400 - 400 Riverside St

June 20, 2005

Subject: Response to Peer Review Comments of November 22, 2004
Lot 4 of the 400 Riverside Street Properties
Applicant, Rist/Brunet Family Trust

Re: August 24, 2004 Planning Board Workshop
Two Multi-Tenant Buildings, Lot 6 of McAlister Farm Subdivision and
Lot 4 of 400 Riverside Street Properties
Rist/Brunet Family Trust, Applicant

C RIPRAP PLUNGE POOL WITH LEVEL LIP SPREADER DETAIL
N.T.S.

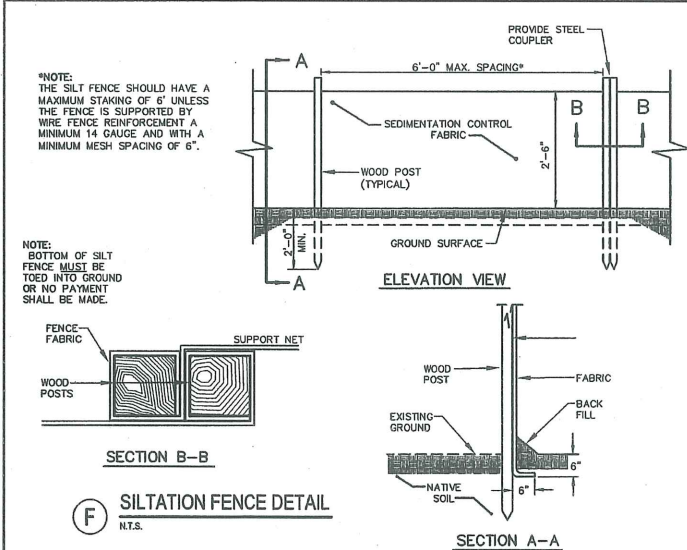
Finally, we have reviewed the previously submitted Level Lip Spreader design computations and confirmed that the 10-year, 4.7-inch peak runoff rates used to size the BMP measures do, in fact, reflect the anticipated peak runoff rates discharging to the two Level Lip Spreaders planned within the development site. Simply stated, the Level Lip Spreaders were sized based on the peak discharge rates generated from the portions of the existing and proposed impervious surfaces within the subcatchment areas that are actually tributary to the Level Lip Spreaders. Accompanying this letter, please find hydrologic computations and supporting documentation for the Level Lip Spreaders. Also enclosed, please find hydrologic computations and vendor sizing worksheets for the two (2) planned Water Quality Units tributary to the Level Lip Spreaders. We note that the Level Lip Spreaders were sized based on the 10-year, 4.7-inch storm even, while the Water Quality Units were sized based on vendor sizing criteria that included the 1-year, 2.5-inch storm event.

In accordance with the design criteria for Level Lip Spreaders provided in the Maine Erosion and Sediment Control BMP Manual, we have included the previously submitted design calculations for the proposed Level Lip Spreaders. The calculations are as follows:

Summary of Level Lip Spreader Design Calculations		
Estimated Design Flow (10-yr, 24-hr storm)	Length (0.25 CFS/LF)	Upstream Flow Area (4 X CFS)
WQUNo. 1 - 4.48 cfs	18.0 ft	18.0 sq. ft.
WQUNo. 2 - 7.23 cfs	29.0 ft	29.0 sq. ft.

Additionally, DHAI has revised Sheet 10 – Erosion Control Details by replacing the reference for a 25-foot long Level Lip Spreader with “Refer to Sheet 5 – Grading, Drainage and Erosion Control Plan for Level Lip Spreader design information”.
